WEST SUSSEX COUNTY COUNCIL CONSULTATION

TO:	Arun District Council FAO: Andrew Wood
FROM:	WSCC - Highways Authority
DATE:	29 June 2020
LOCATION:	Land adjacent to 45 The Ridings, East Preston, BN16 2TW
SUBJECT:	EP/67/20/PL 1 No. detached house & formation of associated new access.
DATE OF SITE VISIT:	N/A
RECOMMENDATION:	Advice
S106 CONTRIBUTION TOTAL:	N/A

DWG NO
935/PO1

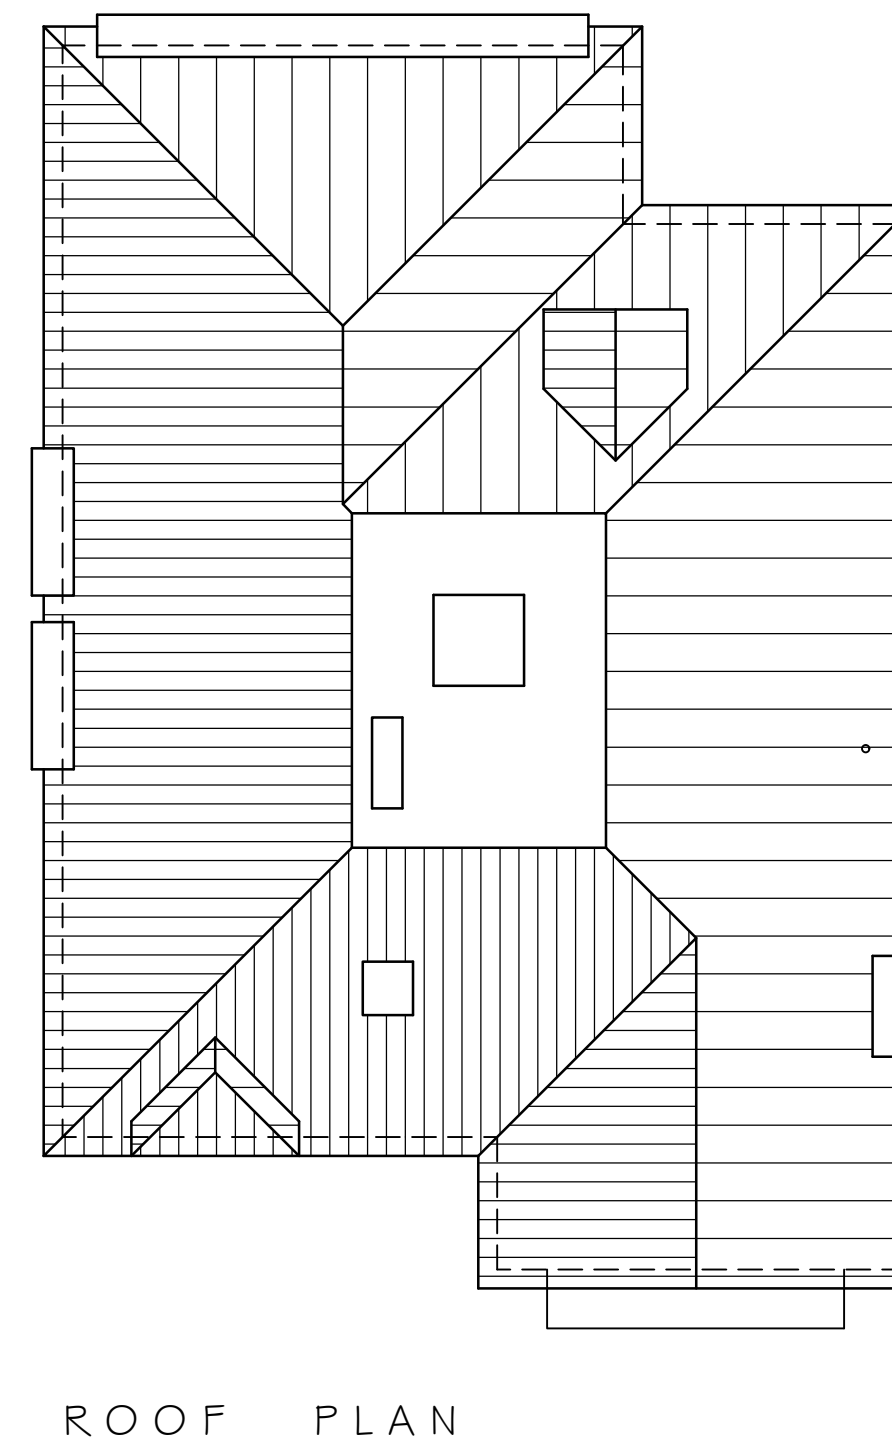
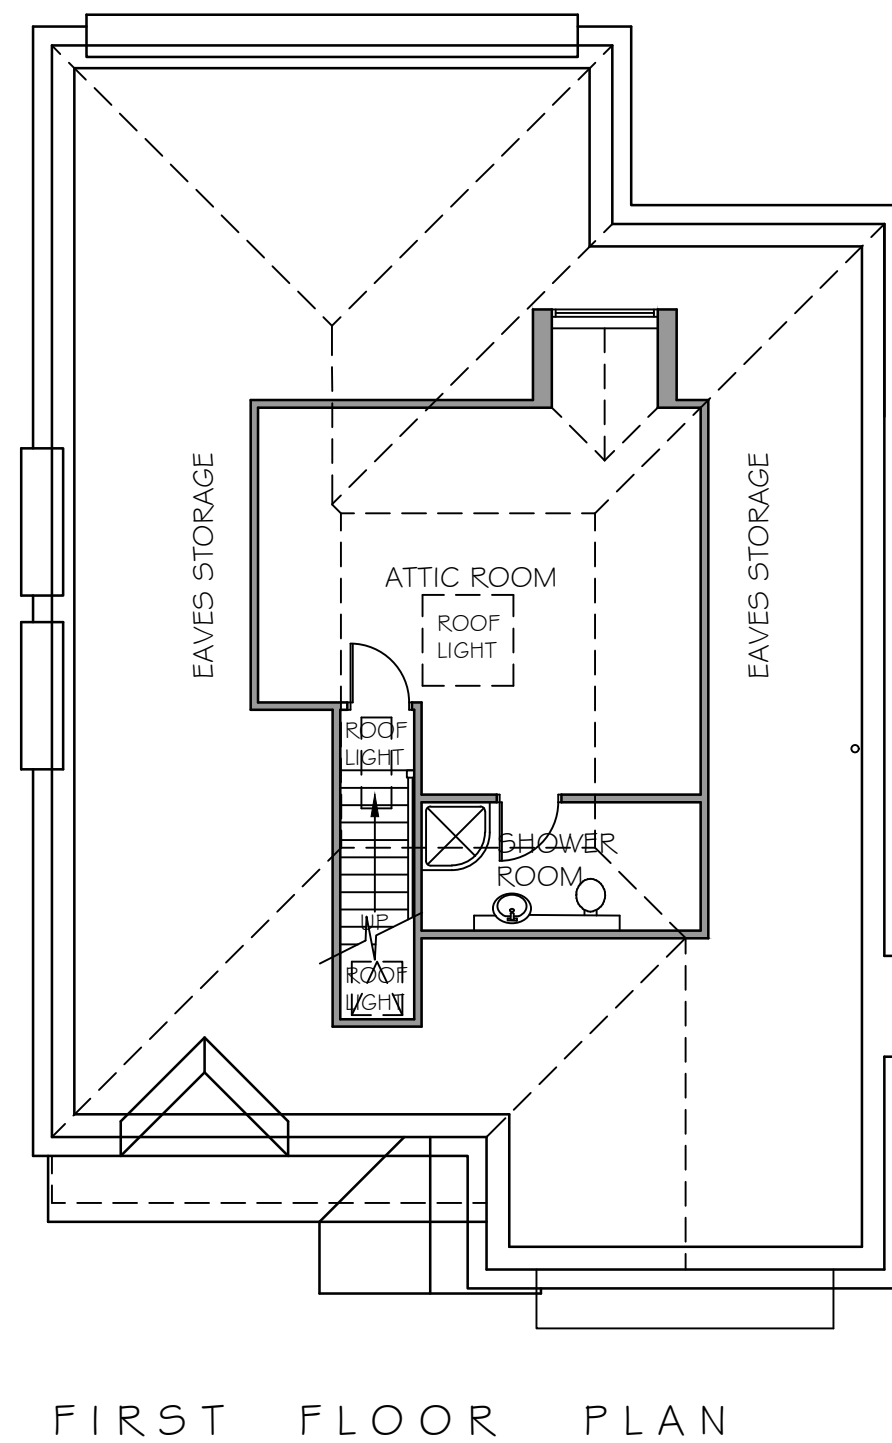
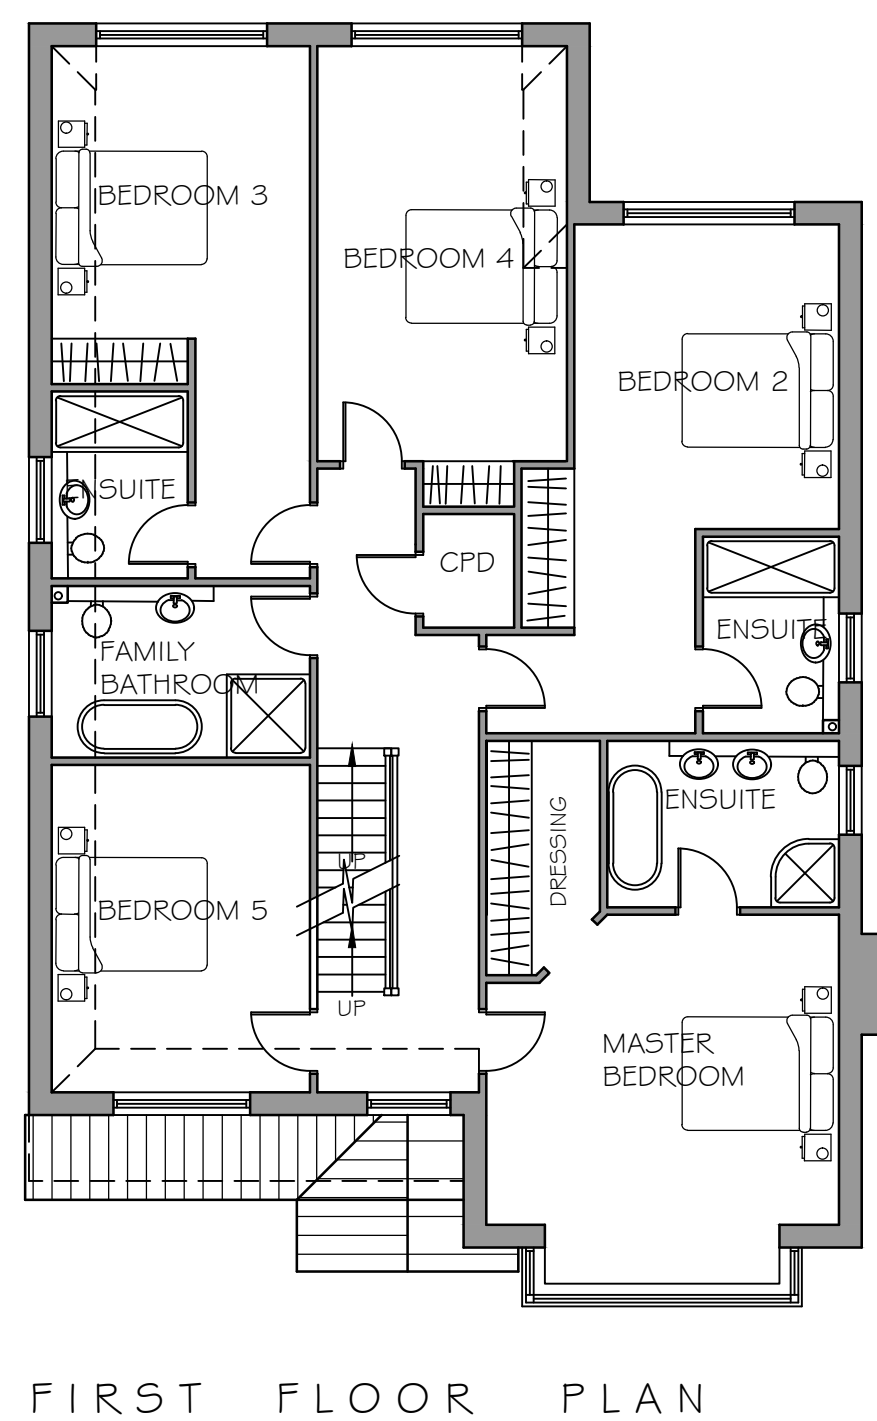
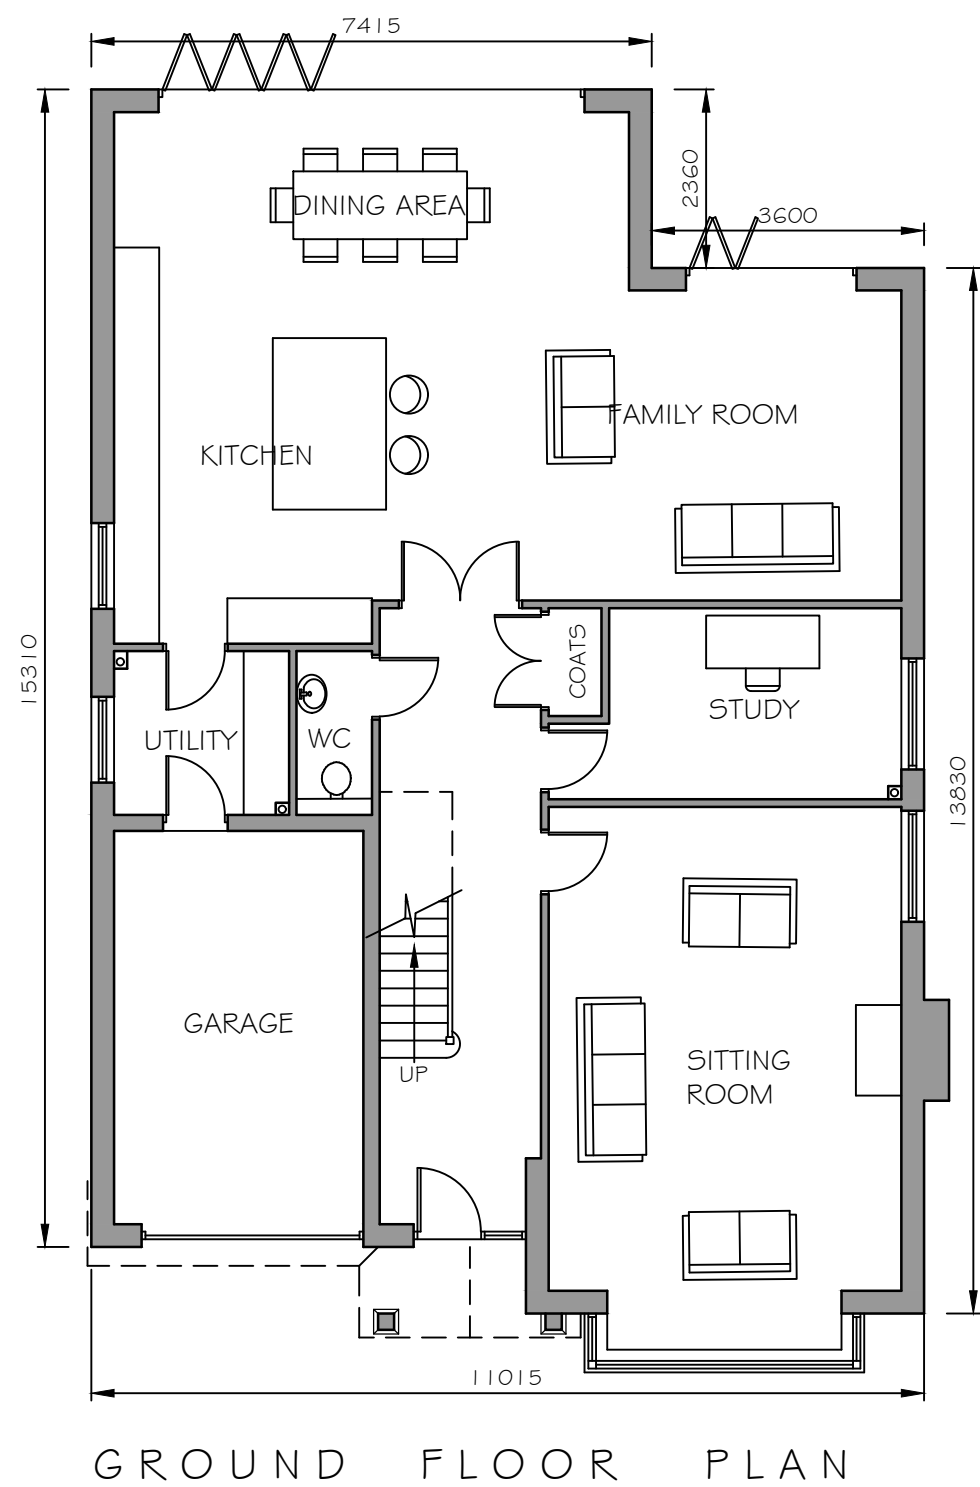
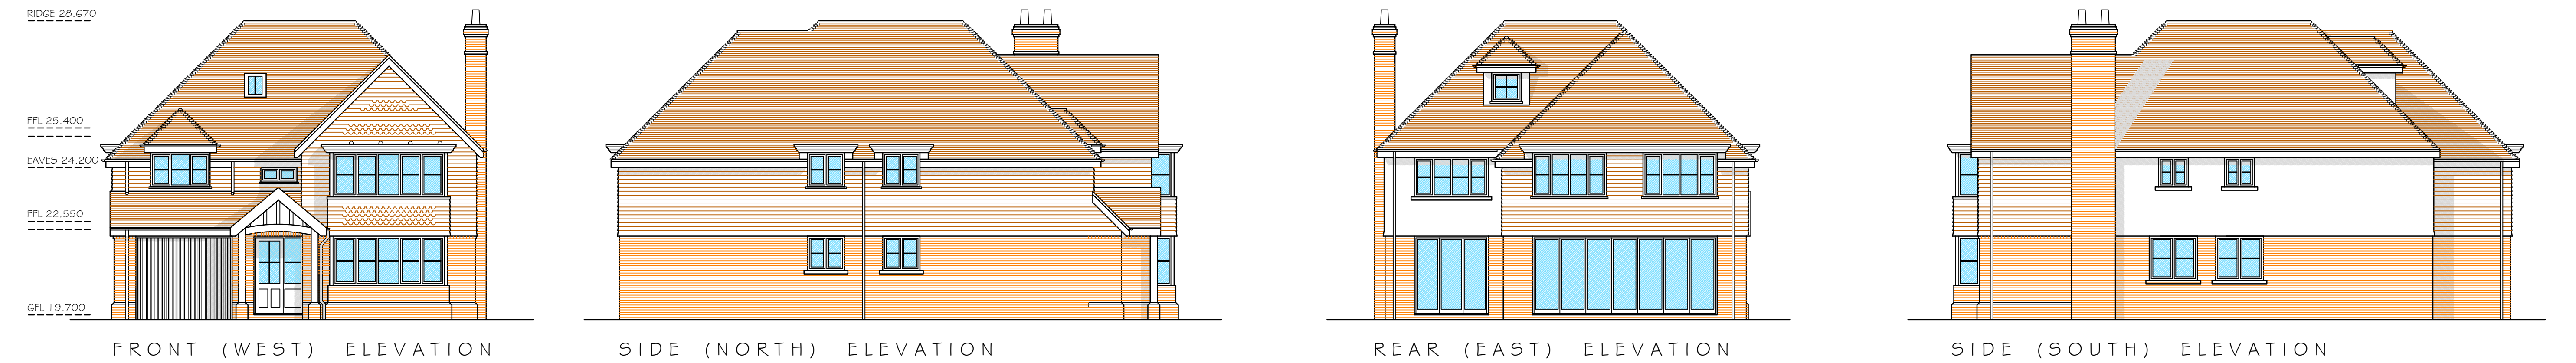
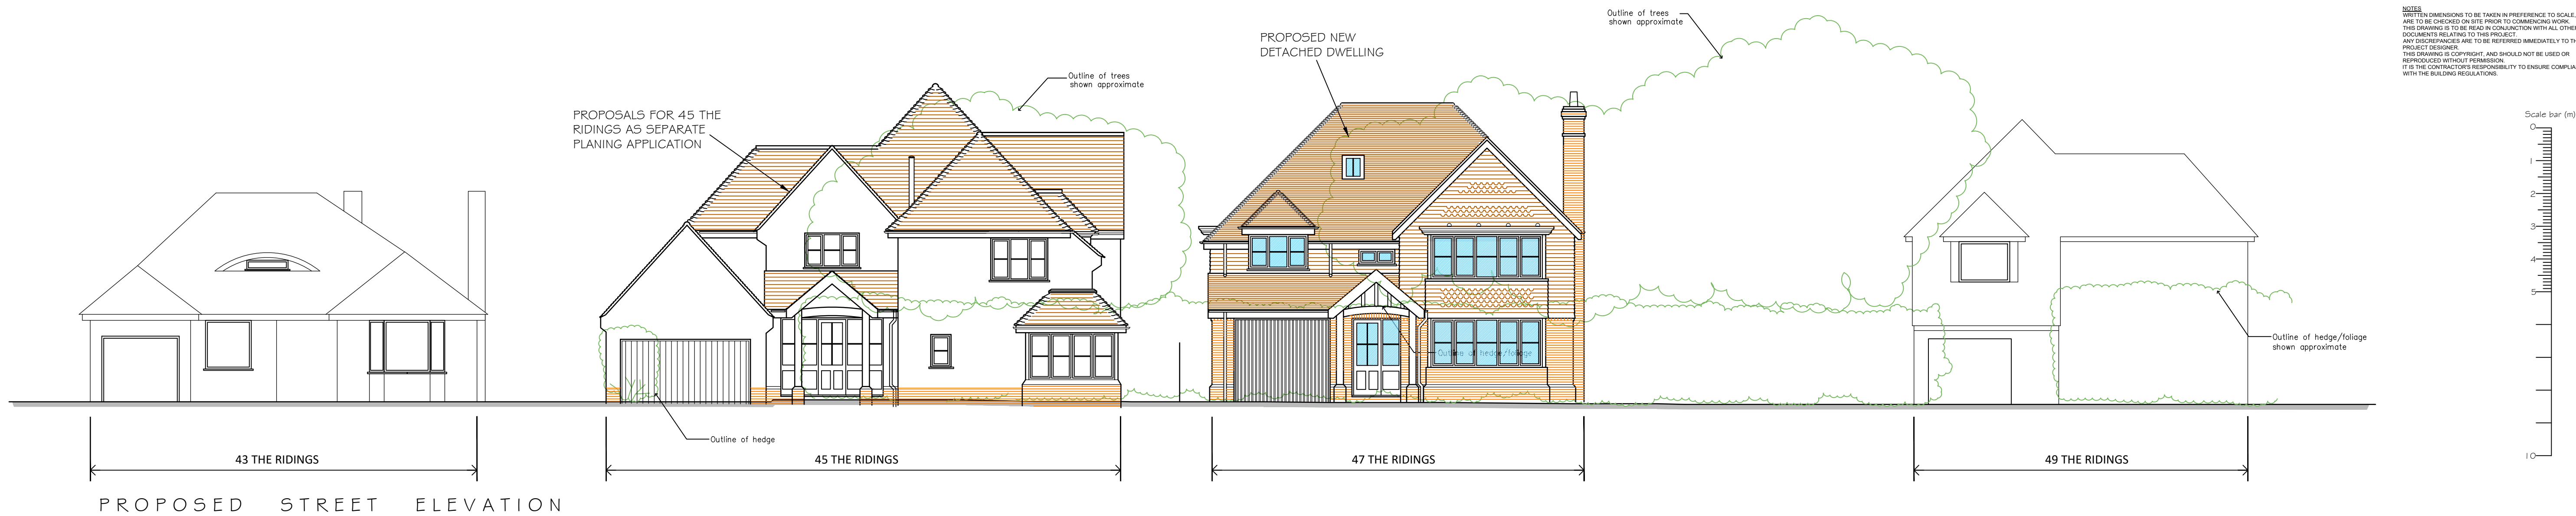
The LHA notes that the proposed garage does not meet the minimum specifications for single car garages of 3m x 6m as set out in Manual for Streets (MfS). The LHA advises the applicant to modify the plans to ensure the garage meets MfS specifications. Notwithstanding this, the LHA is satisfied that the plans demonstrate adequate parking provision.

The applicant proposes four cycle parking spaces. However, this has not been demonstrated in the plans. The applicant should demonstrate cycle parking in the form of covered and lockable storage. If the garage is modified to meet MfS specifications, the LHA can consider it for both vehicular and cycle parking provision.
